CITY OF ALBUQUERQUE

**Re: Barlow Shop
6205 Wilshire Ave NE
30-Day Temporary Certificate of Occupancy
Transportation Development Final Inspection
Engineer's/Architect's Stamp dated 12-11-19 (C18D070)
Certification dated 5-29-20**

Site Plan

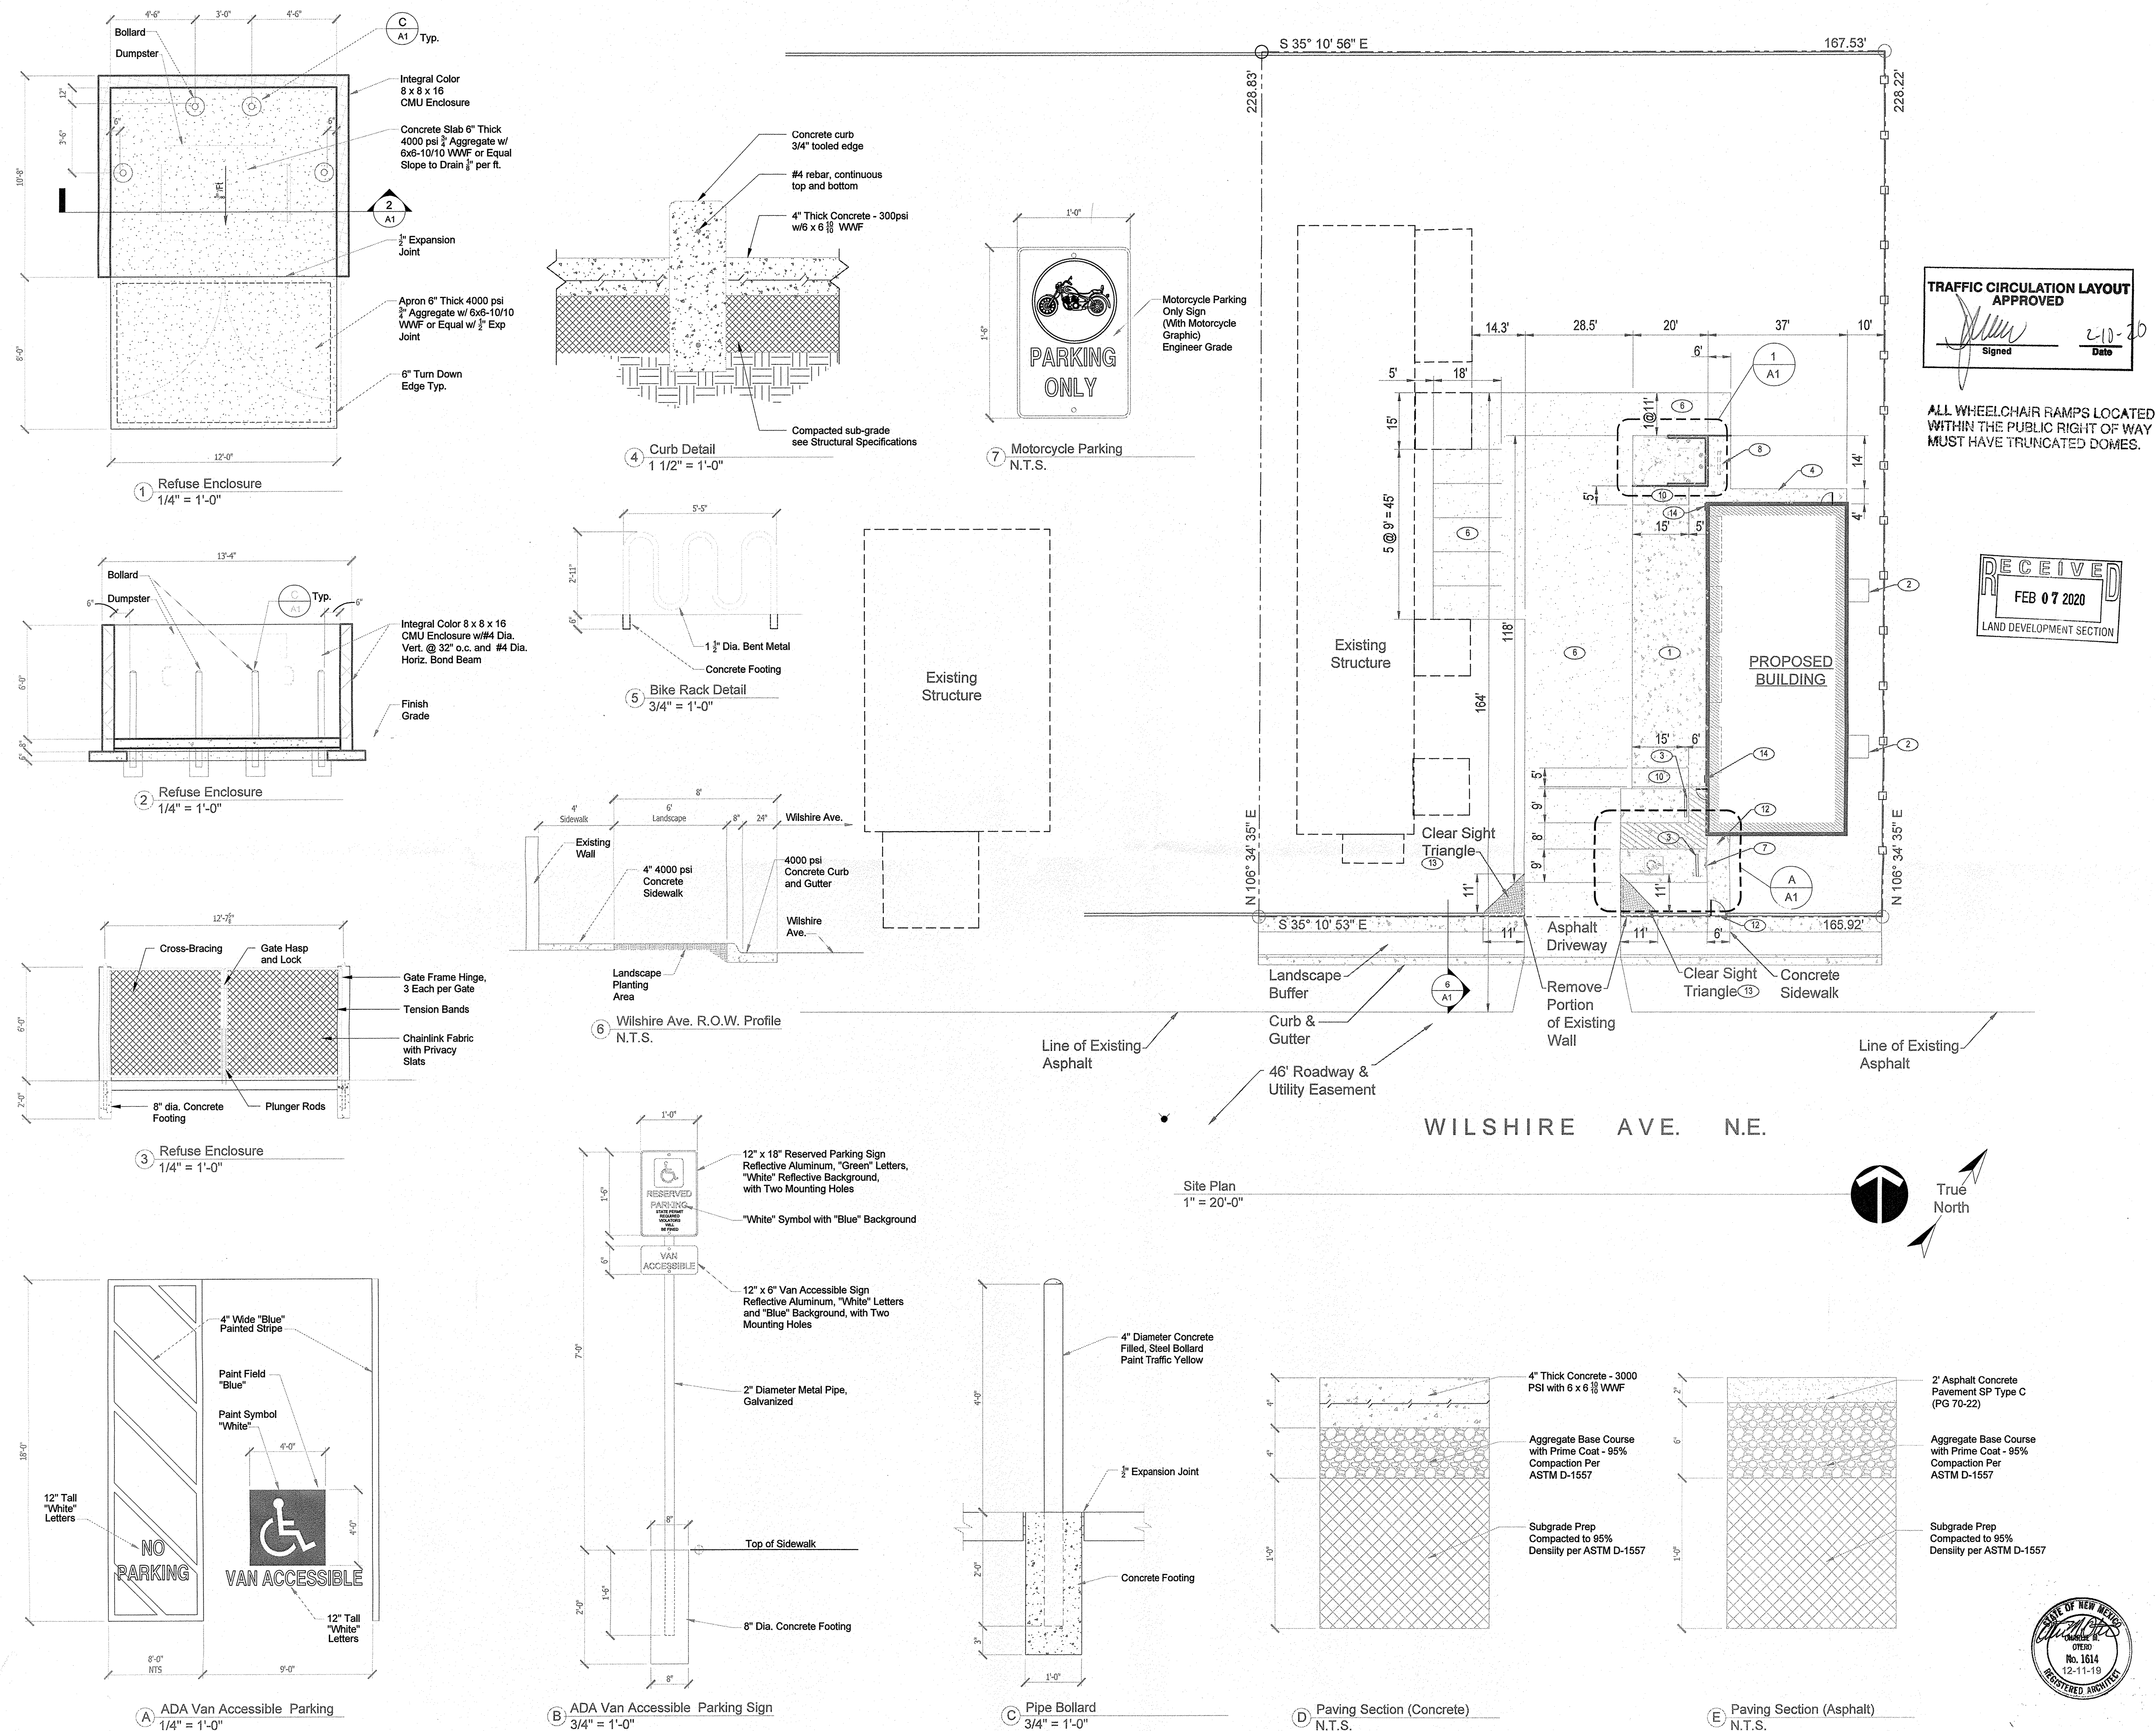
- Please add Parking Table to TCL (Required & Provided)
- Please relocate bike rack. (Obstructs ADA stall and or ADA walk path) Bike standards attached to email.
- Please add Motorcycle sign.
